Council Reference: DA04/1527.07 LN42053
Your Reference:

6 September 2013

Development Application (Council reference DA04/1527.07) - amendment to Development Consent DA04/1527 for construction of facilities for the breeding and growing of Morton Bay Bugs (DIPNR DA DA-282-11-2004-i MOD 2) at Lot 706 DP 1000580, Lot 707 DP 1000580, Lot 708 DP 1000580, Lot 709 DP 1000580, Lot 710 DP 1000580, Lot 1 DP 267742, Lot 1 DP 578962, Lot 128 DP 1039348, Lot 32 DP 847319, Lot 1 DP 227034, RES 1001008, ROAD 3340, ROAD 480, ROAD 1865, ROAD 1070, ROAD 1435, No. 355 Cudgen Road Cudgen

Figure 4: Location of the temporary wastewater discharge in a drainage channel near the main channel of the Tweed River.

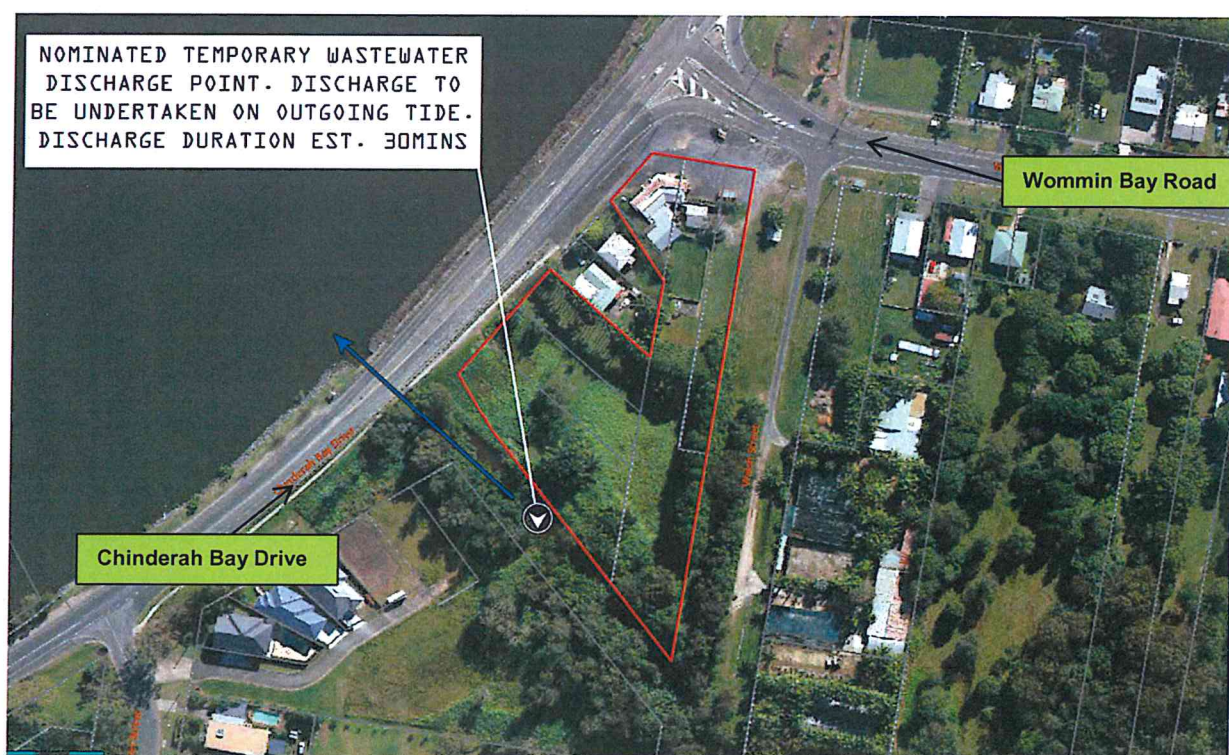
Having considered the temporary nature of the proposed discharge of waste seawater, Tweed Shire Council grants owners consent for the temporary use of the existing drainage channel at Chinderah, subject to conditions of consent.

- Potential impact to the banks / bed of the existing drainage channel as a result of the proposed discharge, resulting in increased turbidity should be taken into consideration. It is requested that Condition 4.1a (d) be amended to include a reference to the drainage channel as well as the Tweed River.
- Concern has been raised with regard to the high ecological status of vegetation surrounding and within the drainage channel. It is requested that a condition of consent be applied such that no vegetation is removed.
- Is the applicant proposing any formal surface treatment for access to the drainage channel? If so, reference is made to the dot point above with regard to there being no removal of existing vegetation.
